**Subject: Canal Landing New Yard – Phase I
40 West Commercial Street
Response to Site Plan Application Review Comments**

DEPT. OF PUBLIC SERVICES REVIEW COMMENTS DATED NOVEMBER 21, 2012

WOODARD & CURRAN REVIEW COMMENTS DATED NOVEMBER 27, 2012

PLANNING COMMENTS FROM BILL NEEDELMAN DATED NOVEMBER 27, 2012

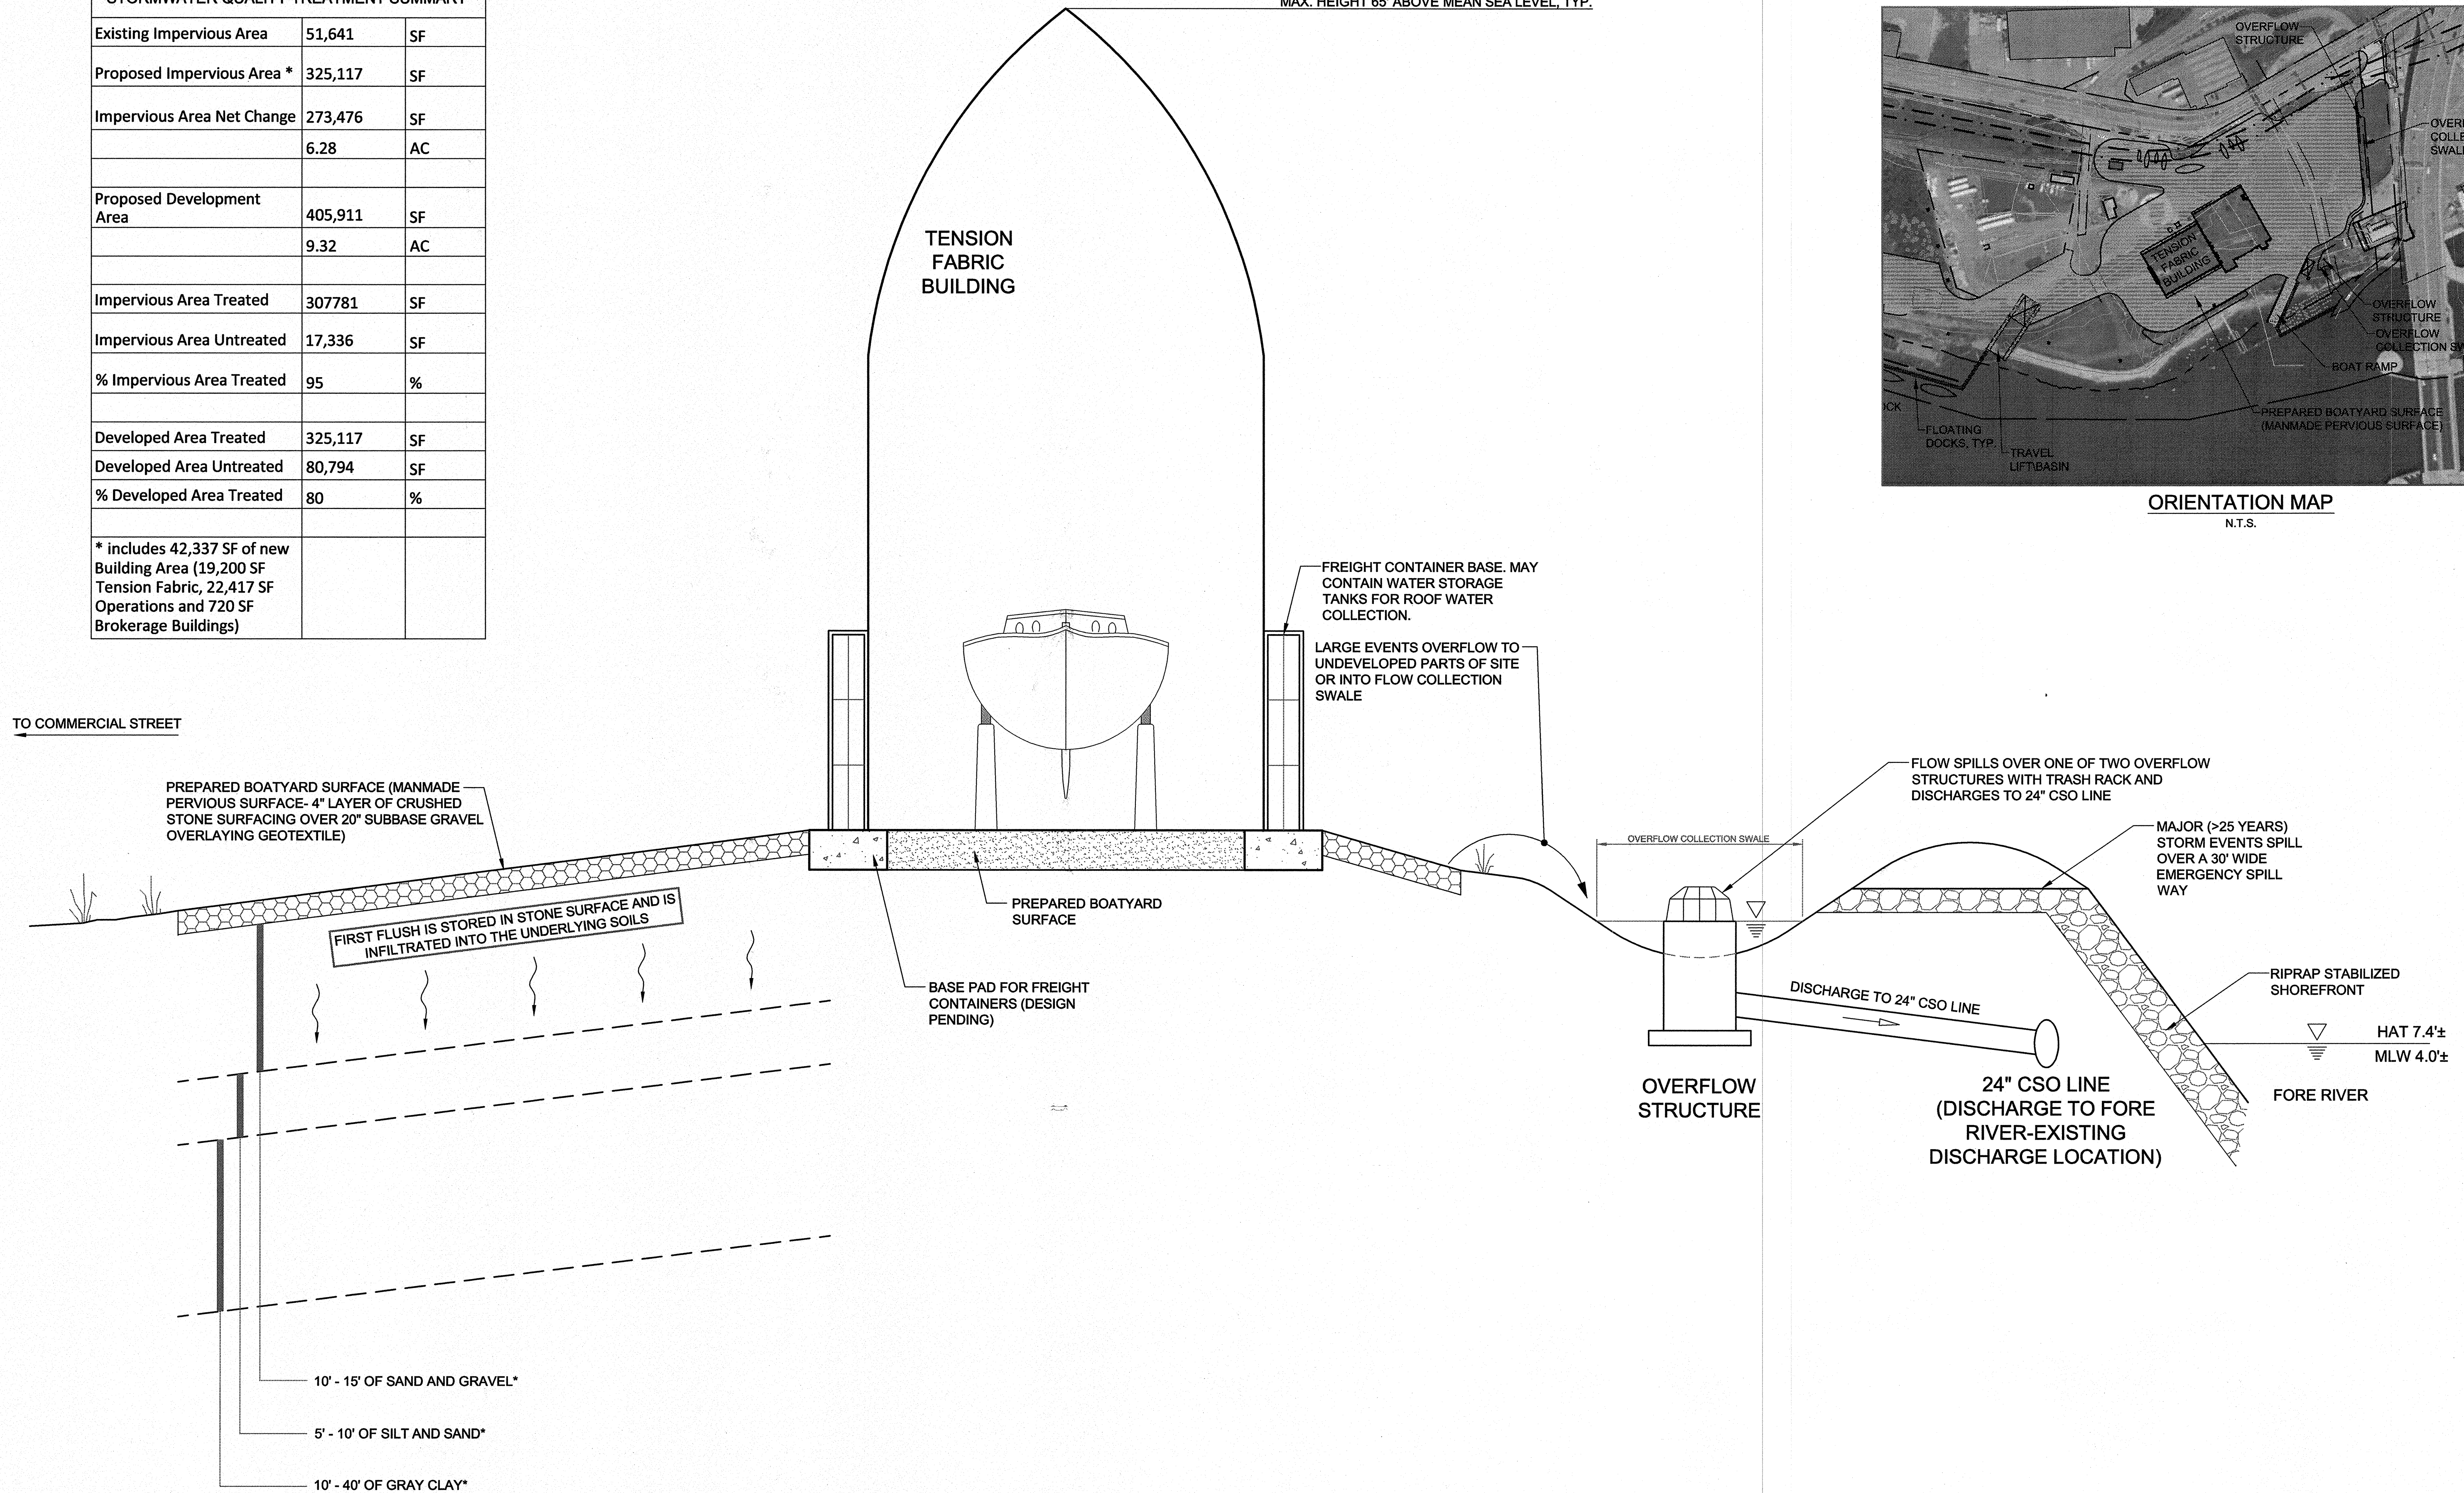
- i) *It is unclear how much new impervious surface is proposed for Phase 1 of this project from the “Project Data” sheet submitted as part of the Site Plan Application form, please clarify. Also, the Applicant references a water quality summary chart on Sheet C-9.0, however no chart indicating these values has been provided at this time.*

The project data sheet and Sheet C-9.0 have been updated and are summarized in the table below:

Existing Impervious Area	51,641 SF
Proposed Impervious Area*	325,117 SF
Impervious Area Net Change	273,476 SF
	6.28 AC
Proposed Development Area	405,911 SF
	9.32 AC
Impervious Area Treated	307,781 SF
Impervious Area Untreated	17,336 SF
% Impervious Area Treated	95%
Developed Area Treated	325,117 SF
Developed Area Untreated	80,794 SF
% Developed Area Treated	80%
